STATE OF NORTH CAROLINA  
DEPARTMENT OF TRANSPORTATION

June 14, 2007

Subject: **Application for the Modification of the Individual Section 404 and 401 permits, and Neuse River Riparian Buffer Authorization for TIP U-3823,** the proposed widening of Airport Boulevard (SR 1158) from NC 42 West to US 264 Alternate in Wilson, Wilson County; NCDOT Division 4. Federal Project No. STP-1158(2), State Project No. 8.2341801. Debit \$475 from WBS Element 34981.1.1.

N.C. DEPT. OF TRANSPORTATION
 DIVISION OF HIGHWAYS
 WILSON COUNTY
 U-3823
 SR 1158 (AIRPORT BLVD.) FROM
 EAST OF NC 42 TO EAST
 OF US 264-A
 DATE: APRIL 2007
 SHEET 4 OF 15

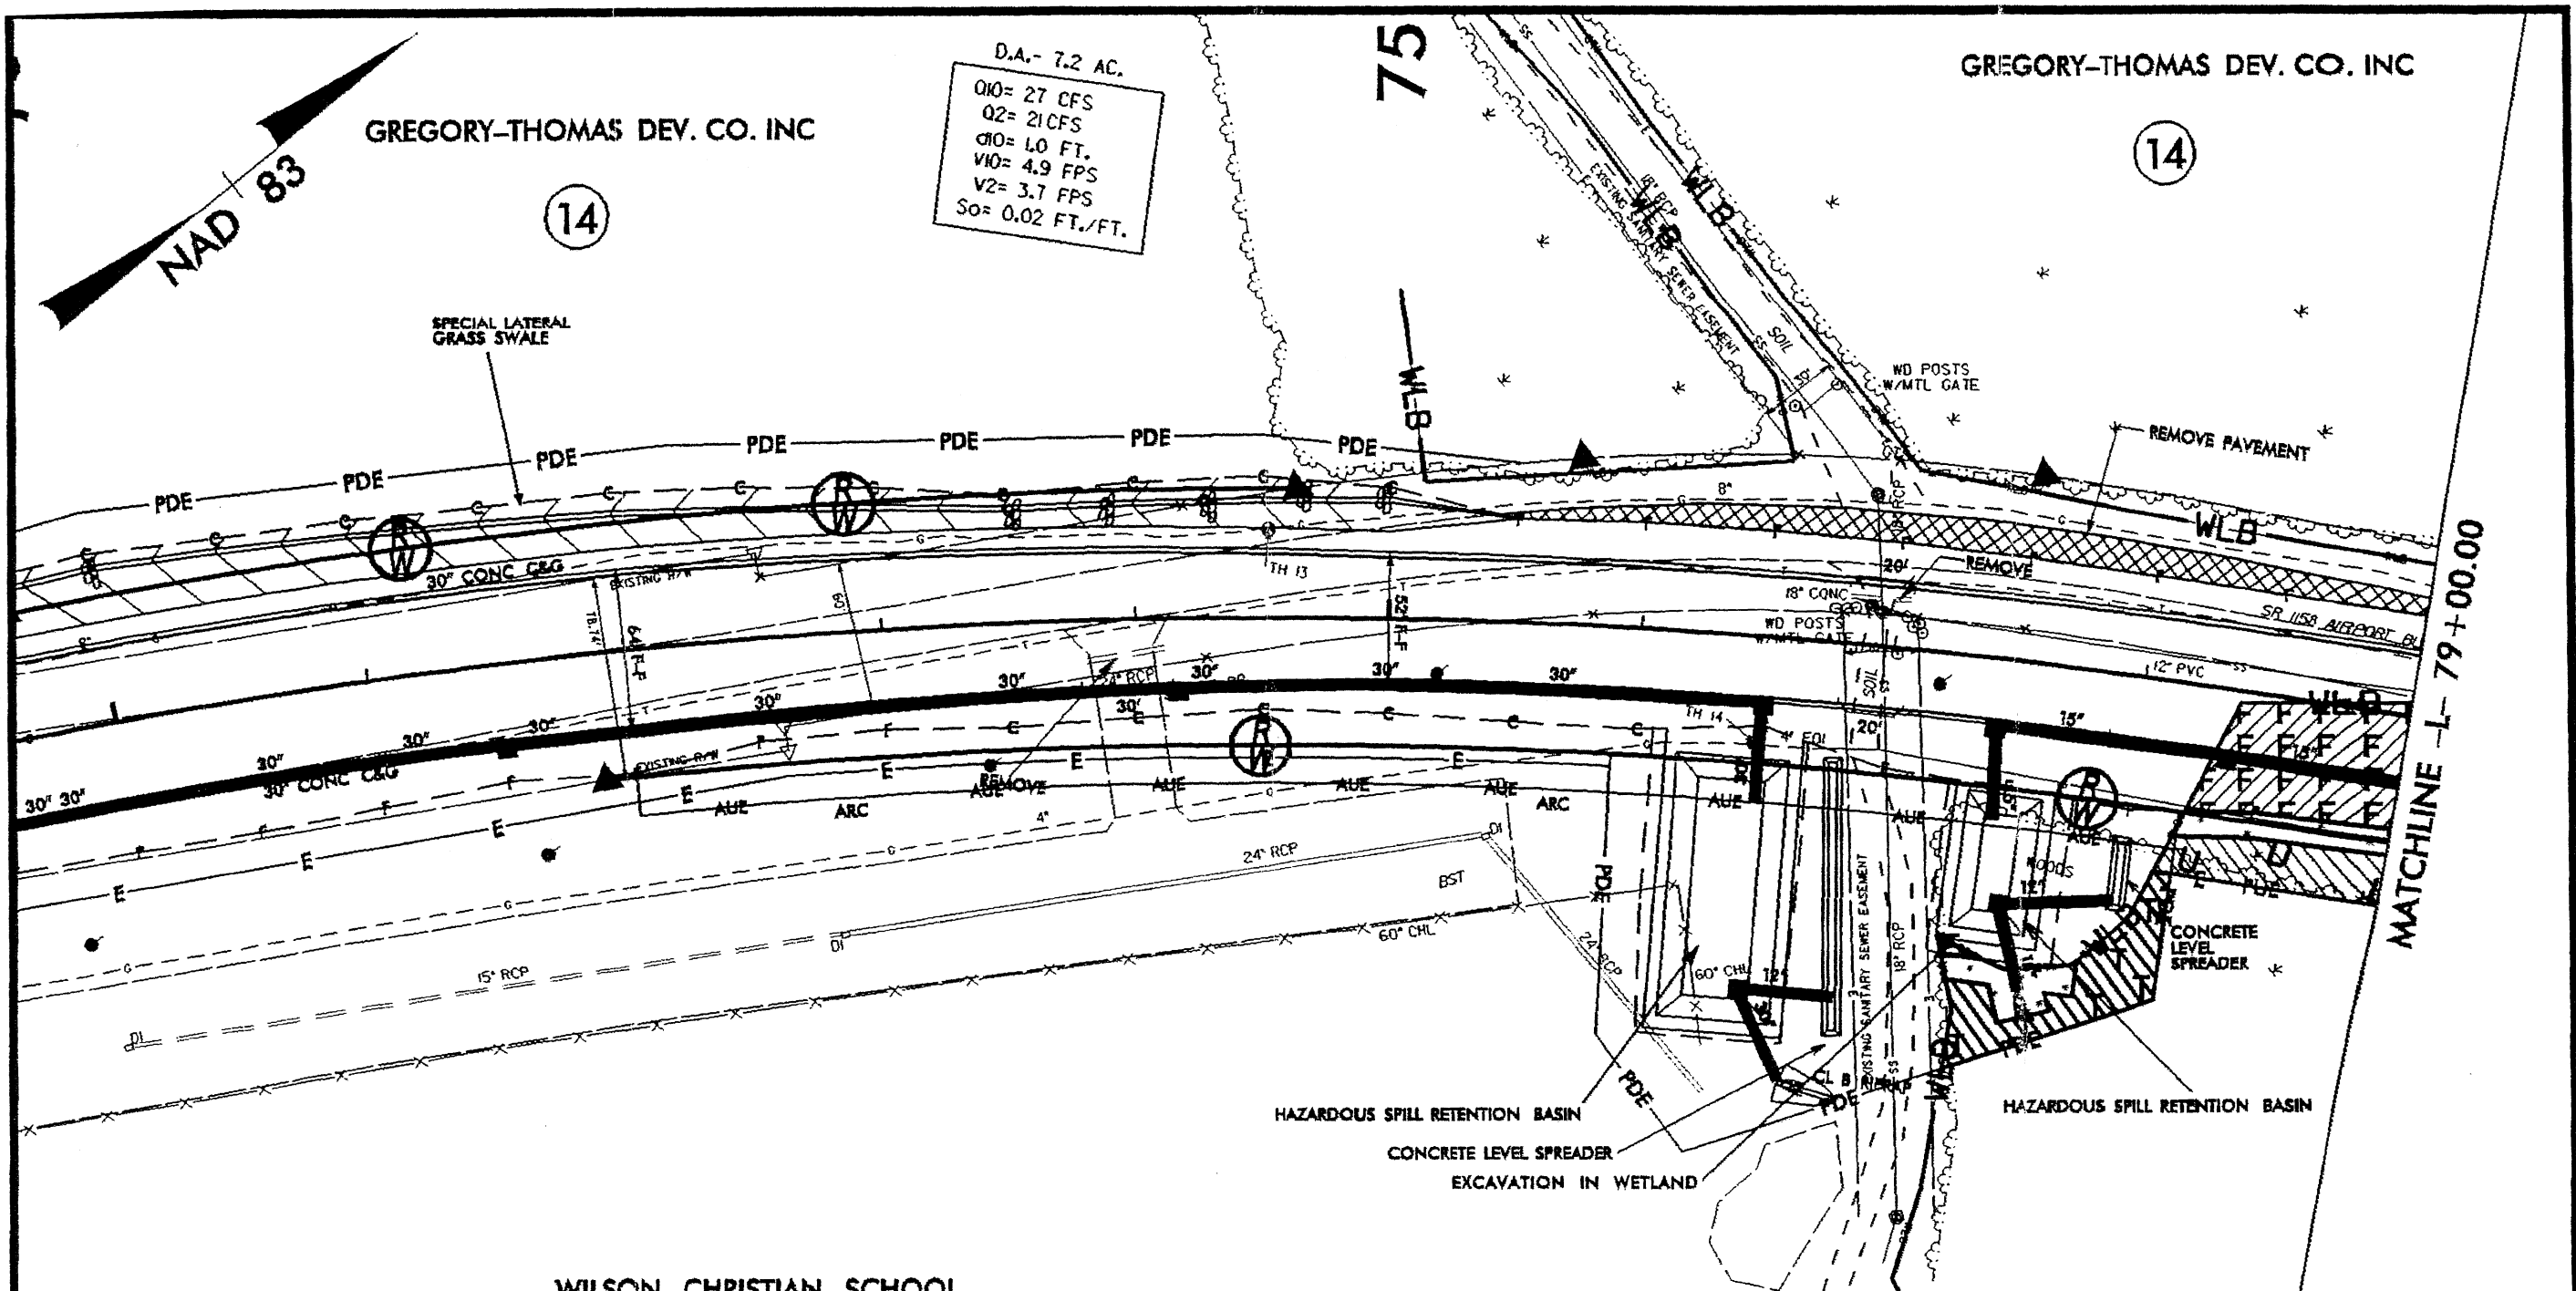
Site 1 (44+95-45+55-L-)

There are NO changes to the amount of impacts for this site, however, the permit drawings have been clarified from "temporary impact in wetlands" to "temporary fill in wetlands".

N.C. DEPT. OF TRANSPORTATION
 DIVISION OF HIGHWAYS
 WILSON COUNTY
 U-3823
 SR 1158 (AIRPORT BLVD.) FROM
 EAST OF NC 42 TO EAST
 OF US 264-A
 DATE: MAY 2007
 SHEET 7 OF 15

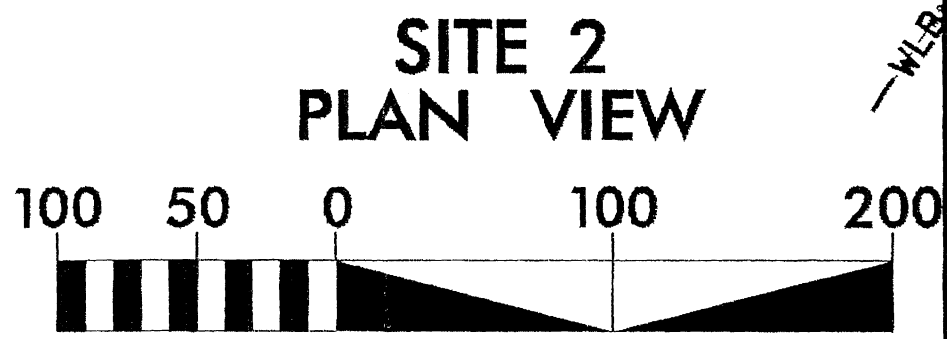
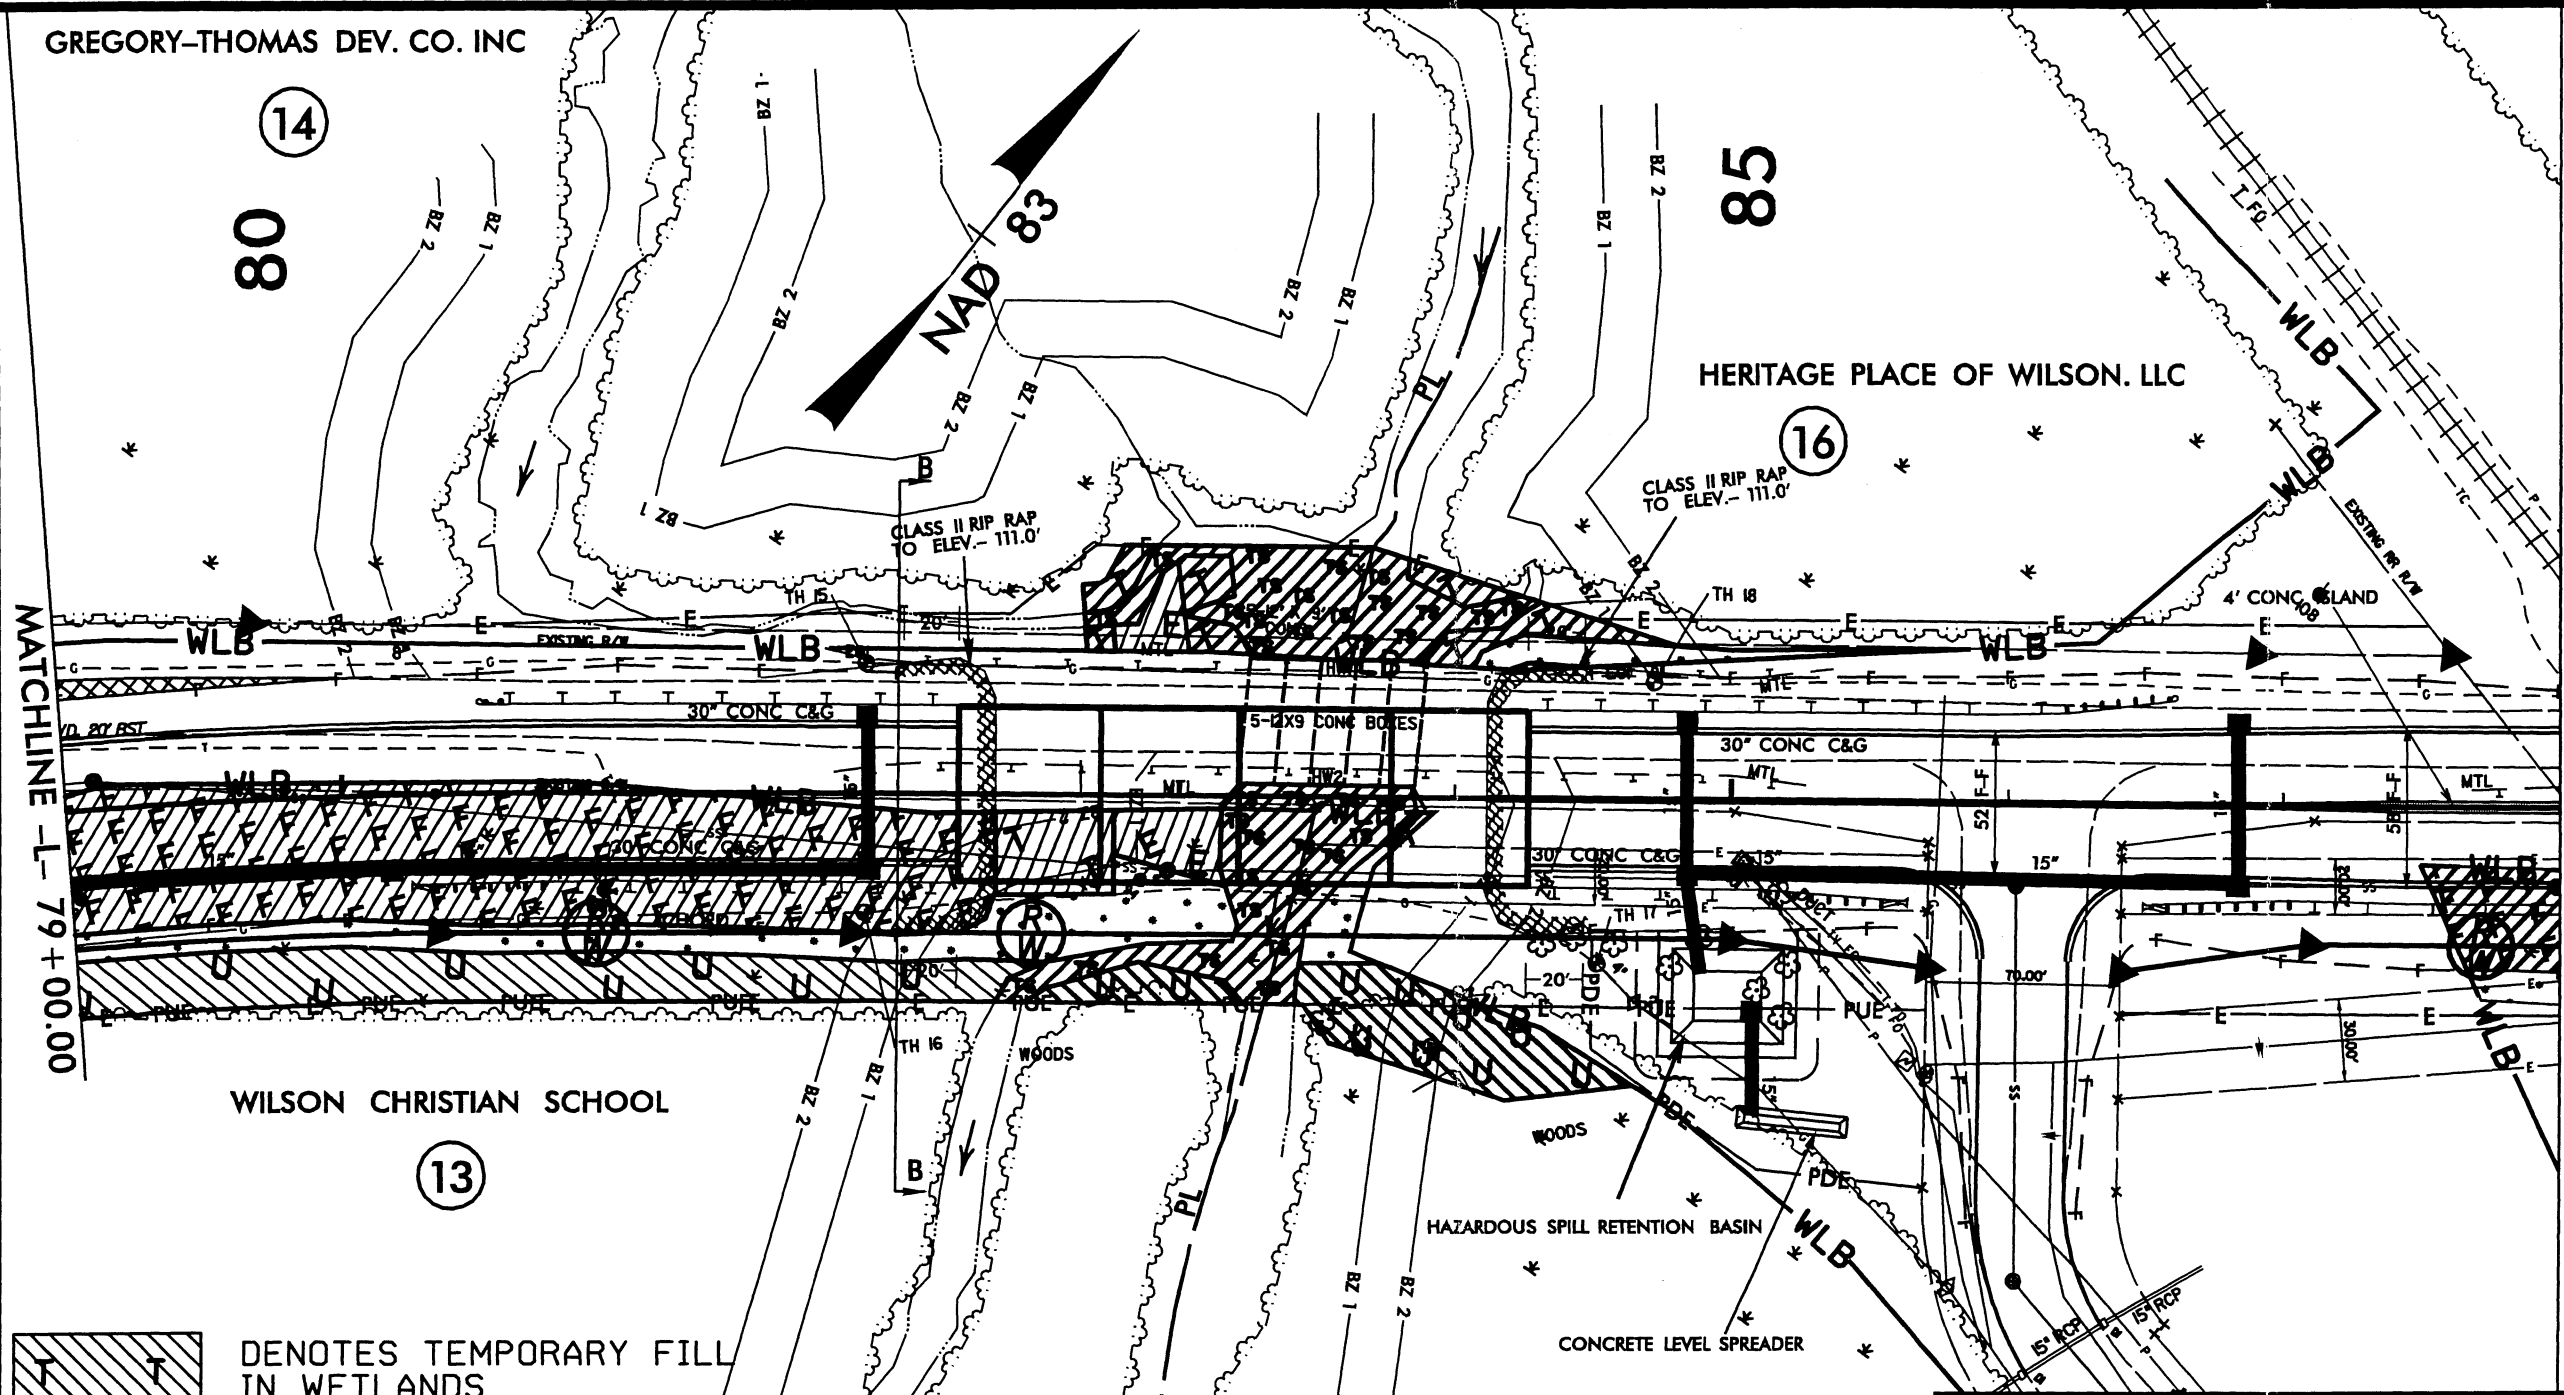
Site 2 (77+25-91+55 -L-)

Due to a re-evaluation of the construction and phasing methods for the removal of the box culvert and replacement with a bridge, along with the relocation of utility and railroad signal control boxes, an increase to wetland impacts has occurred at this site.

NCDOT continues to propose to remove the 12' x 9' pentuple barrel culvert, and replace it with a 4-span, 205-foot cored slab bridge carrying Bloomery Swamp. However, to allow for a cleaner and expedited removal of the existing box culvert, NCDOT will remove the entire culvert at one time. To accommodate this removal, the total permanent impacts to wetlands have increased as shown in Table 1 below, and in the attached drawings.

These proposed activities have also increased the impacts to the Neuse River Riparian Buffer as summarized in Table 2 below, and shown in the attached drawings. These proposed buffer impacts are considered allowable due to bridging.
